South Downs National Park Authority

Principal Areas of Disagreement Summary Statement - Final Issue

29 July 2024

Table 1 – Outstanding Principal Areas of Disagreement

Tree Preservation Order and Hedgerow Plan

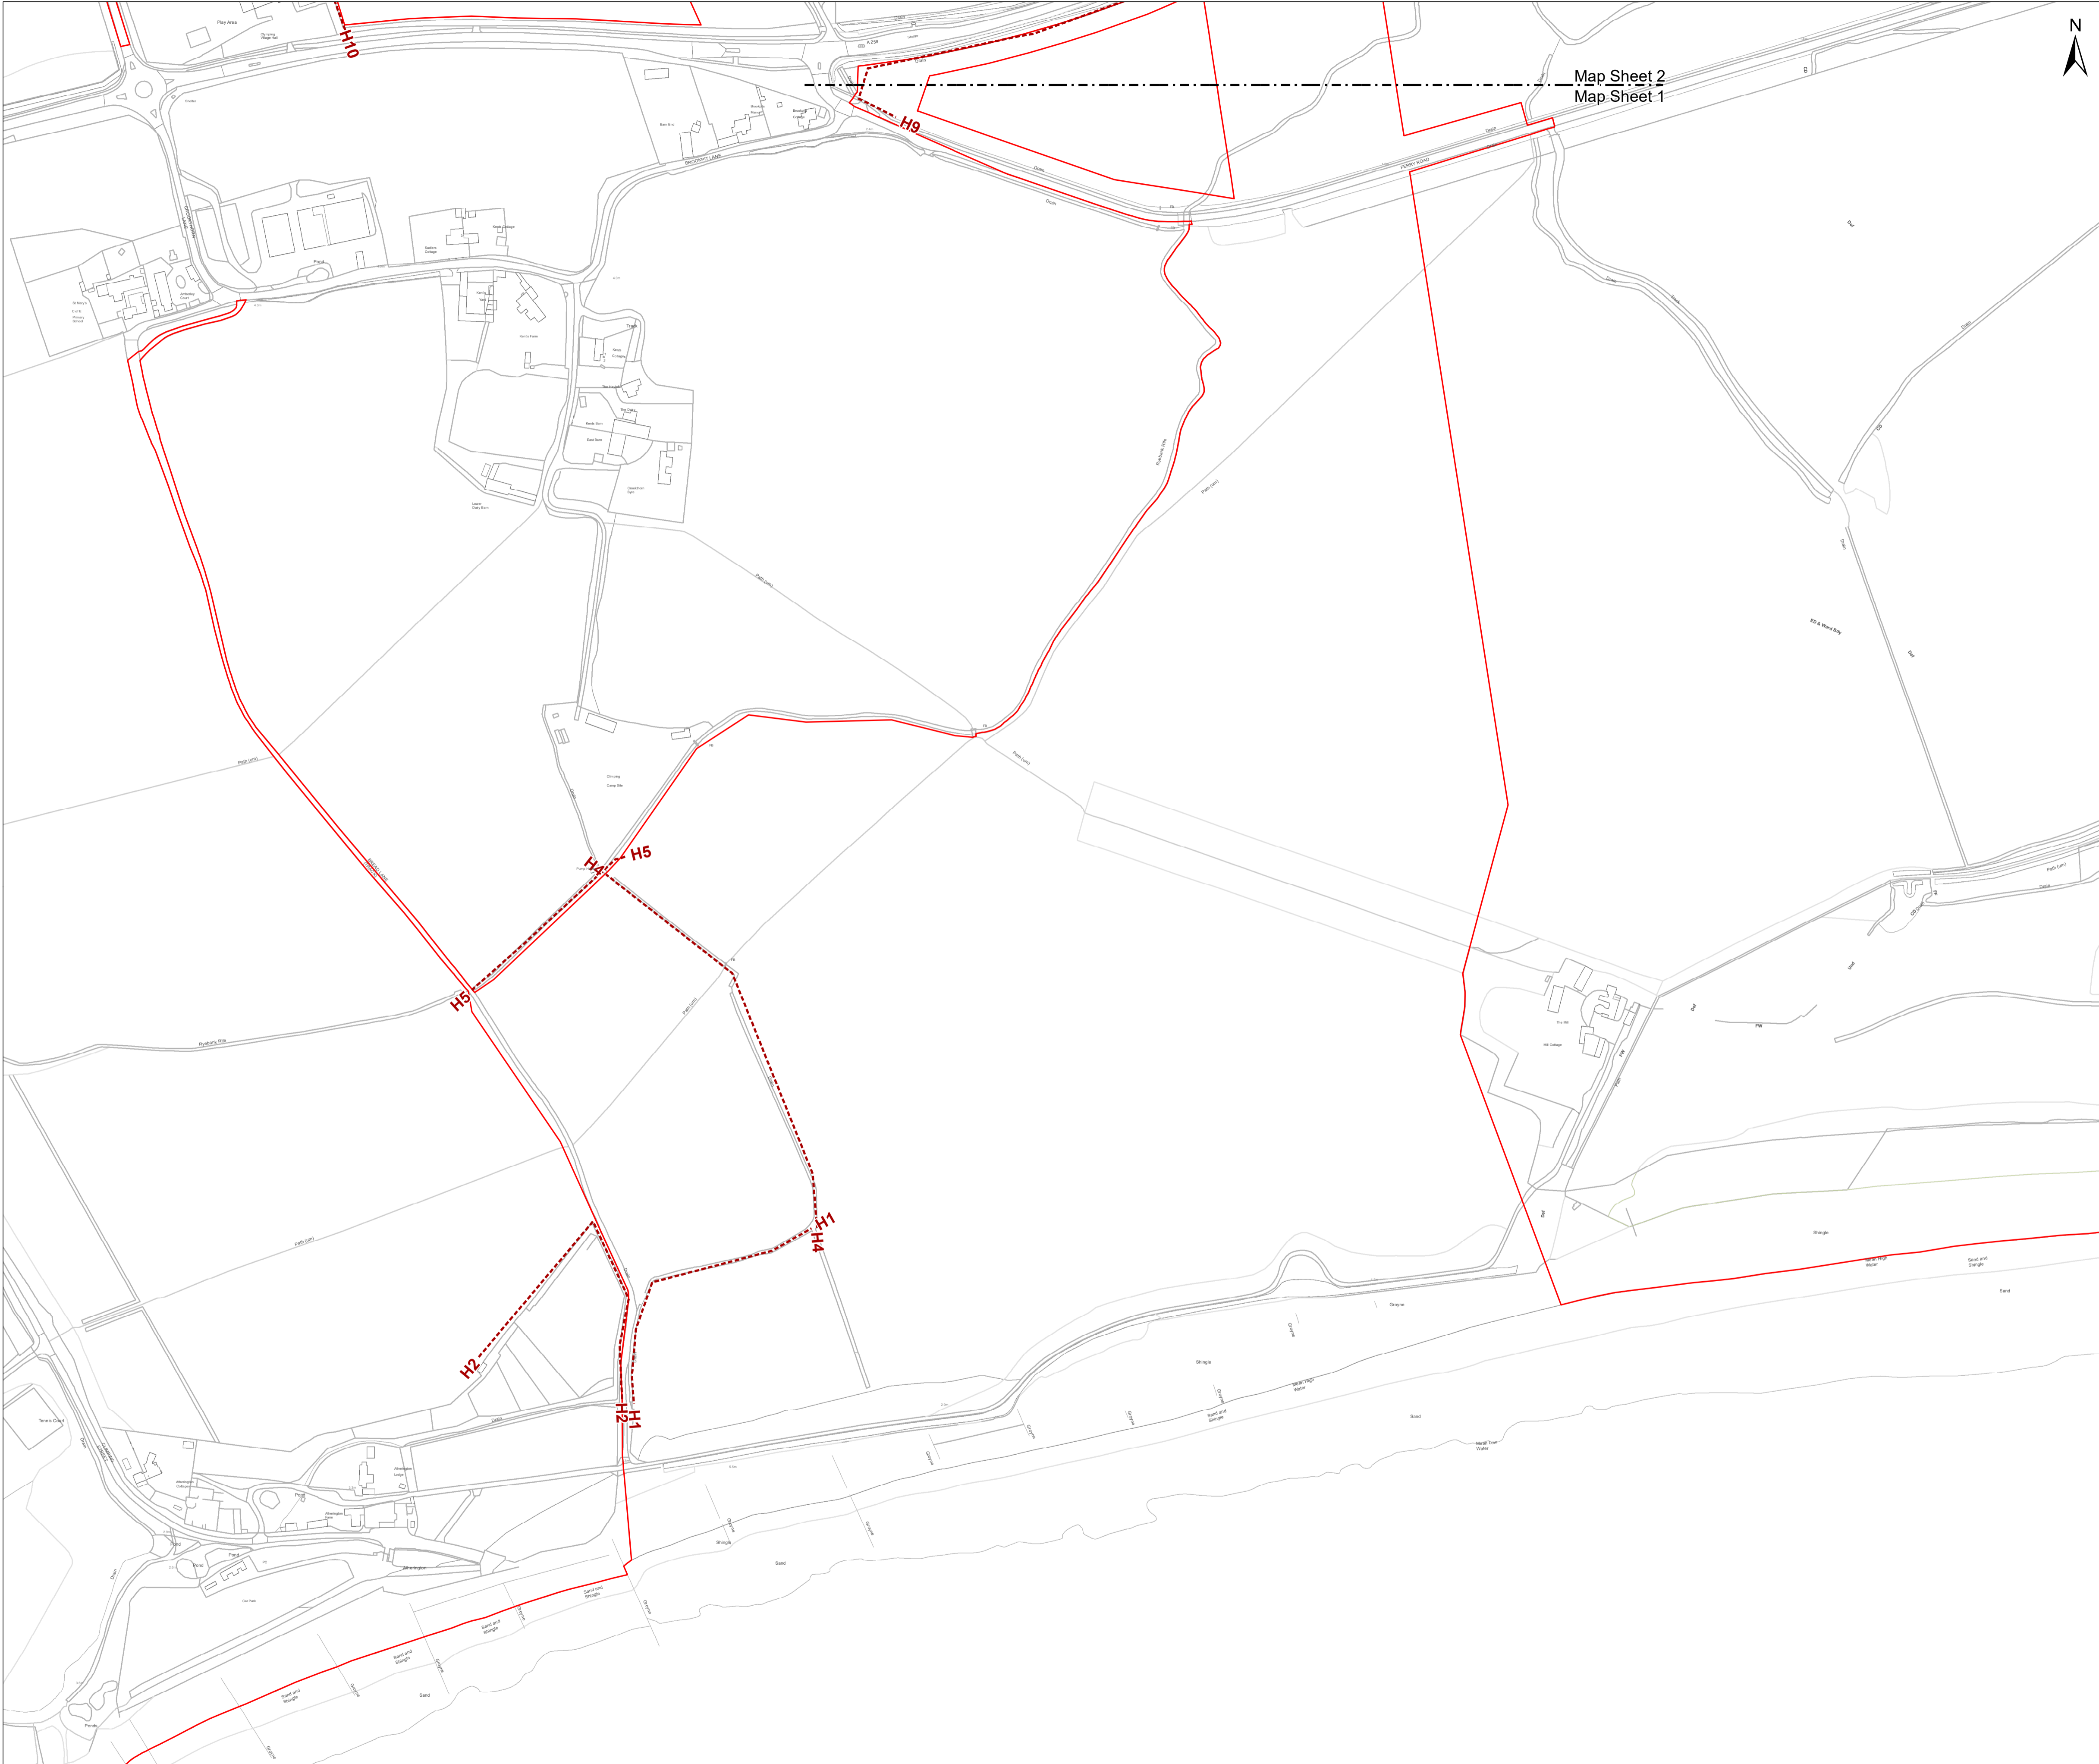
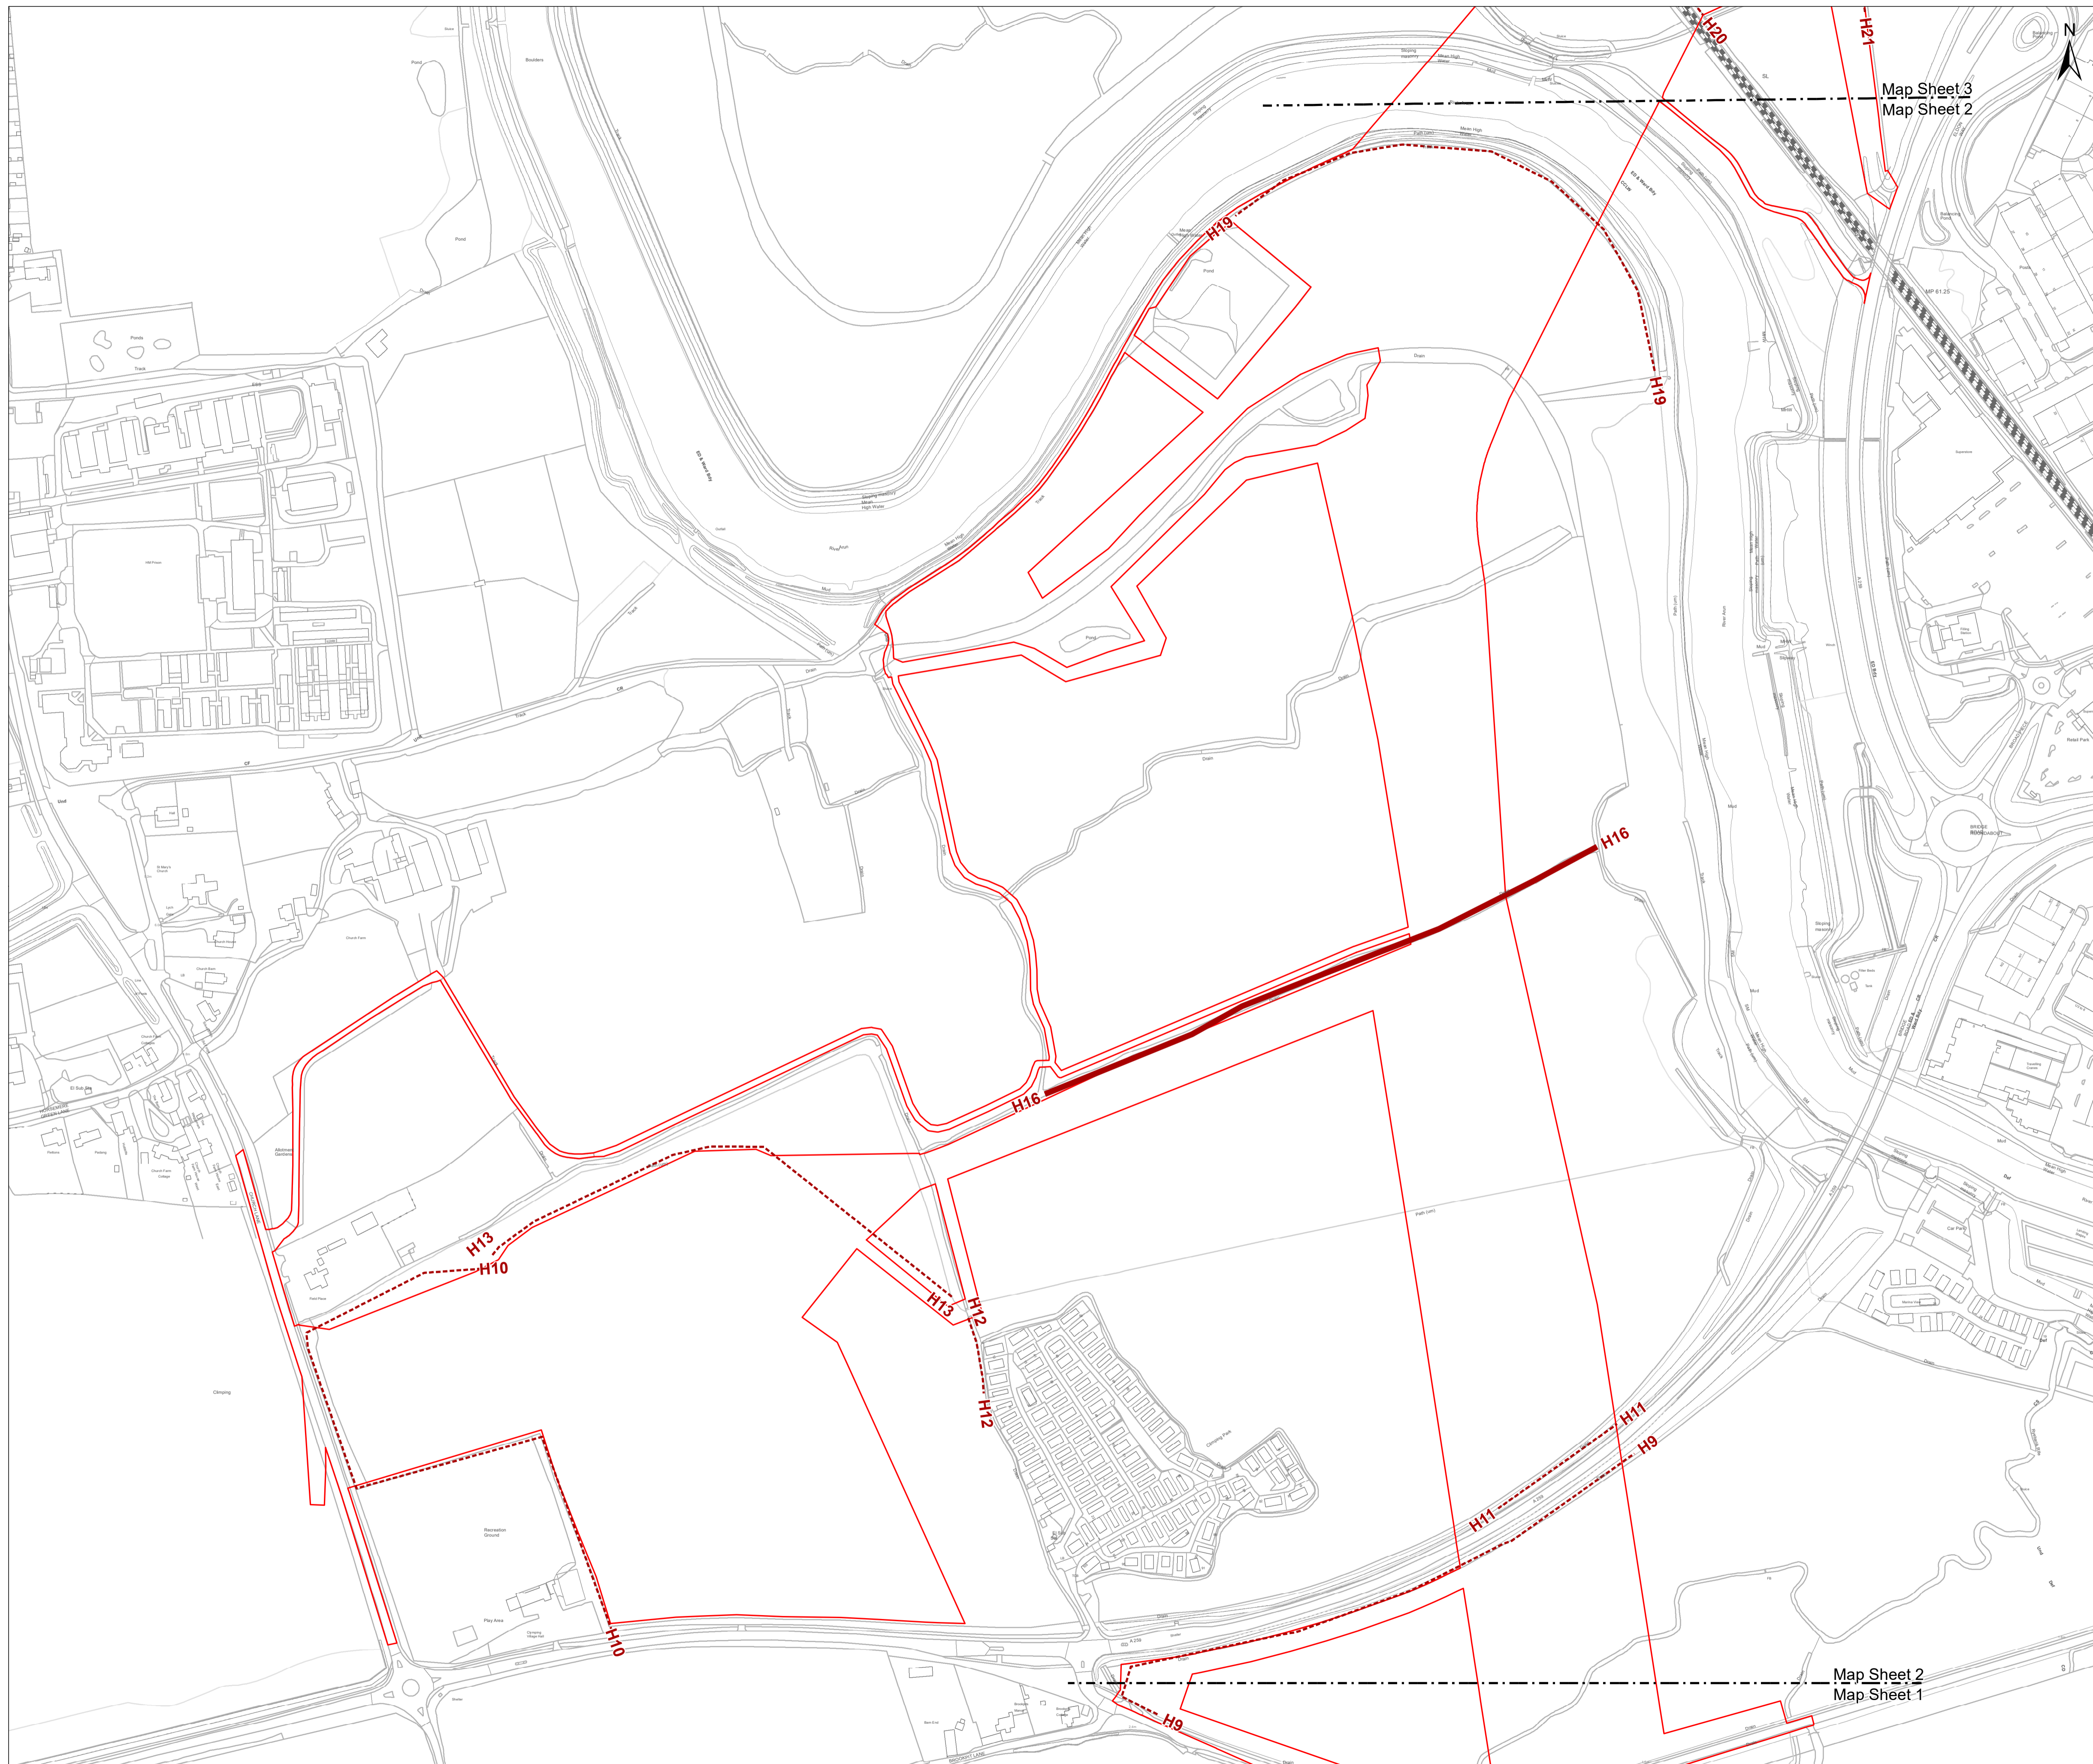
SDA-15	Loss of key Landscape Features	<p>Significant concerns over likely success of proposed hedge notching. The examples cited for use of the technique in the Lake District and Norfolk Broads are not likely to have encountered the challenges of dry, free draining chalk soils. No proven testing undertaken to evidence proposals. If this would not work, the landscape, ecological and visual impact would be significant.</p> <p>Clarity required to explain why 6m width notching technique cannot be used for all hedges regardless of importance.</p>	<p>Applicant to provide further evidence on achievability on shallow chalk soils in Southern England.</p> <p>Applicant to provide further evidence on reasoning.</p>	<p>SDNPA are still not satisfied the proposed hedge notching will be successful in these landscape conditions. Further to this, it will not be possible to reinstate tree belts or mature trees in hedgerow, which are intrinsic features of this landscape. The effects are therefore far greater than the applicant has concluded.</p>
